City of Portland Mail - load bearing question

SolarEdge Three Phase Inverters

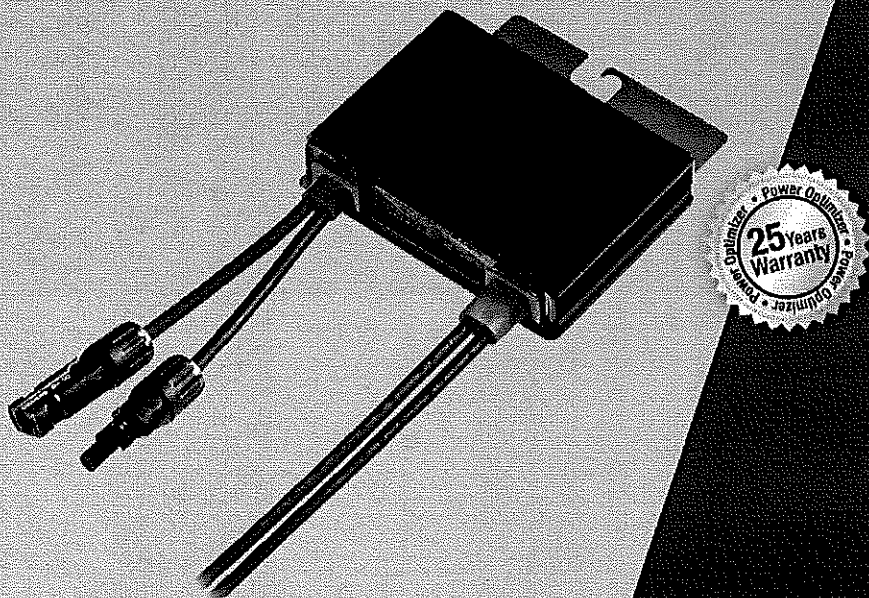
I just wanted to confirm that your system will have a rapid shut down switch for when the Fire department needs to kill the power.

Yes I did see this. SolarEdge is compliant with rapid shutdown. Their older inverters can be upgraded with a rapid shutdown kit, but most of their new ones have this feature already installed. (see attached - highlight on the first page)

Portland Public Library Solar array

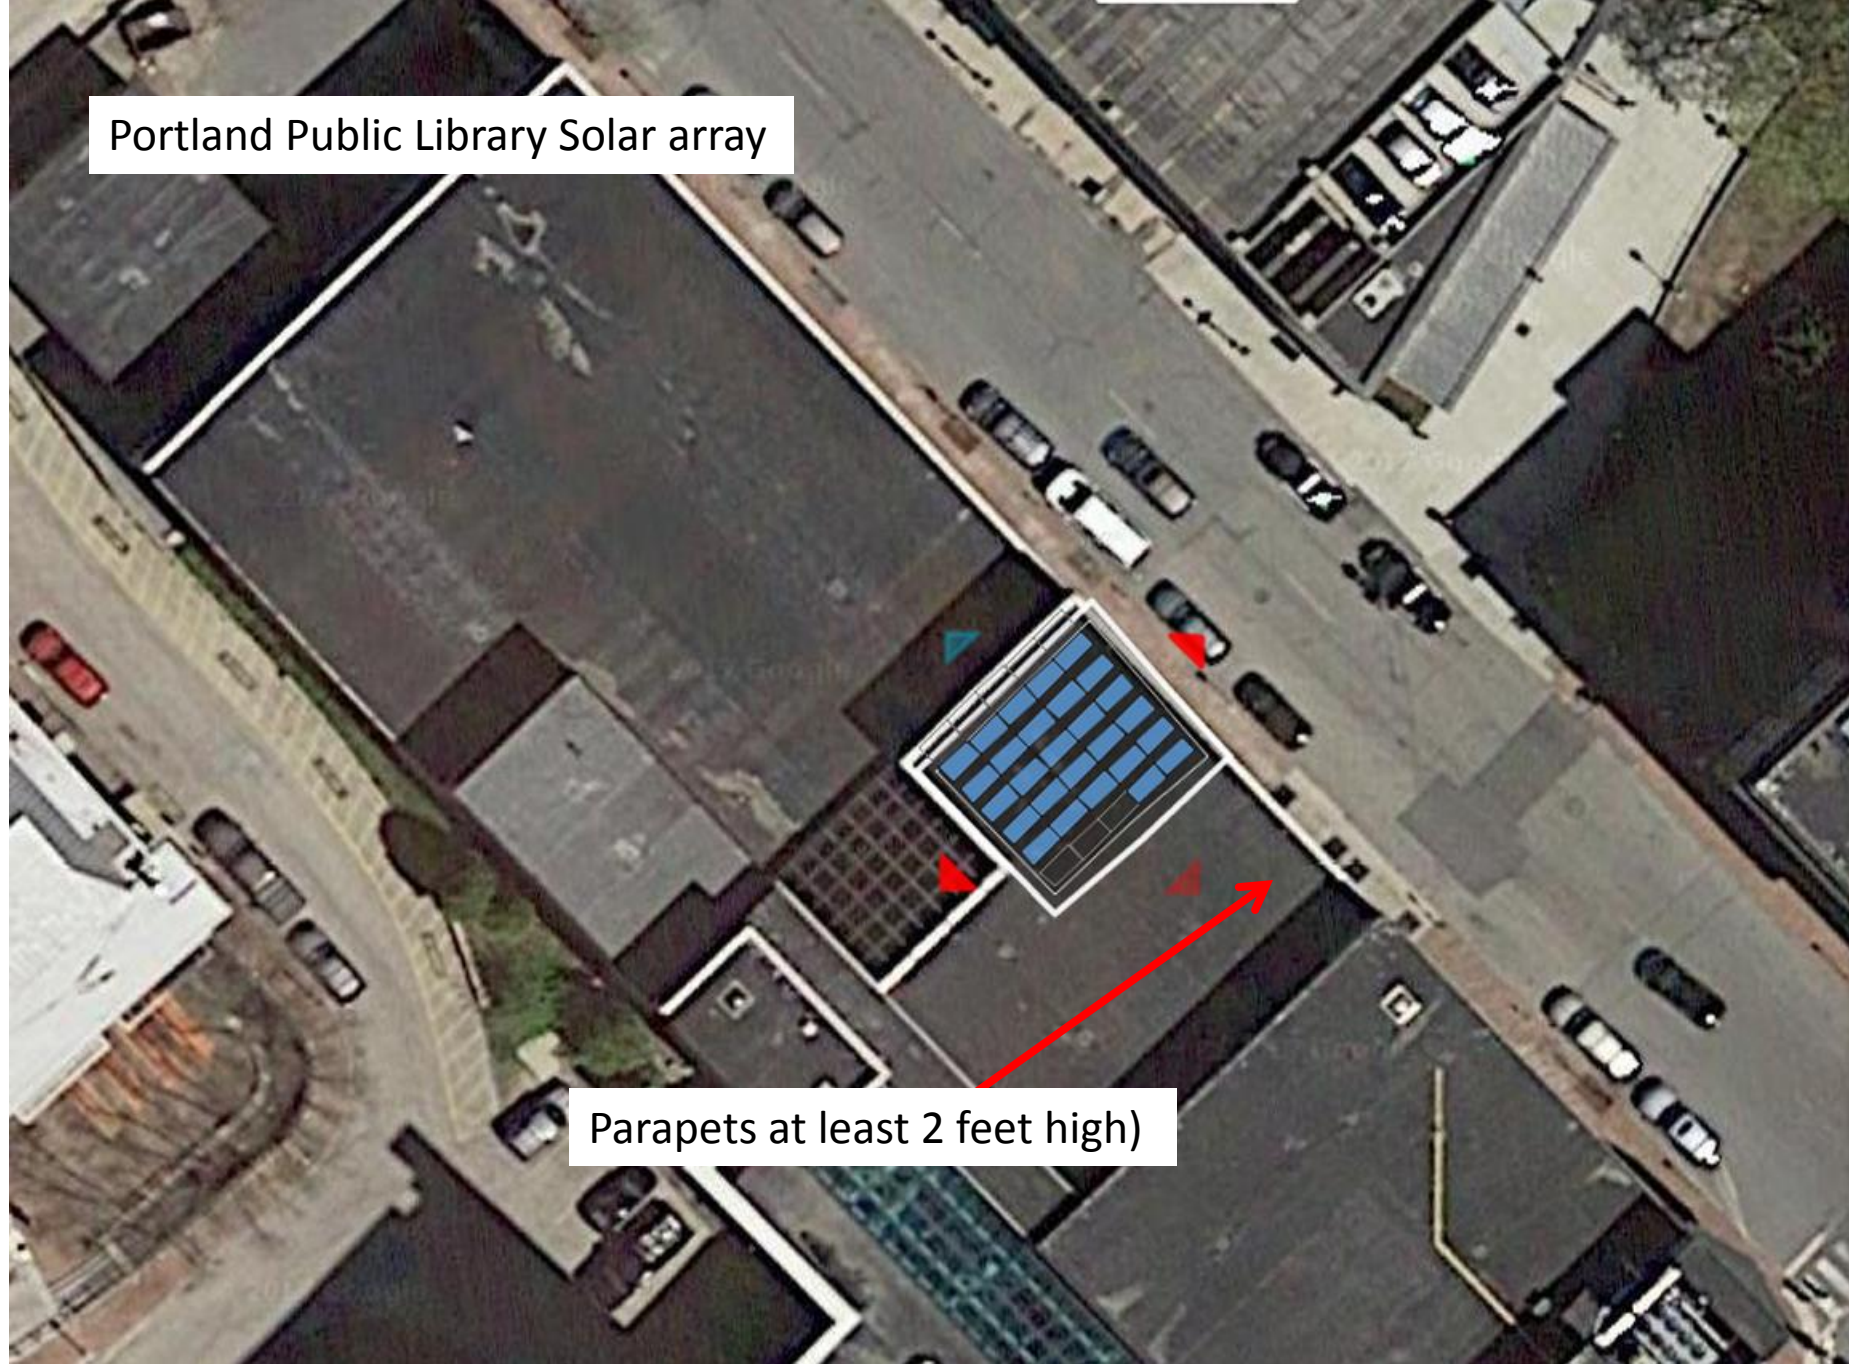
2: *Please point out the egress points on the roof. Is there emergency hardware on the door(S)?*

There are two doors that open directly to the roof deck from the third floor - one to an office area and the second to the main hallway. They are locked from the outside. See attached photo.
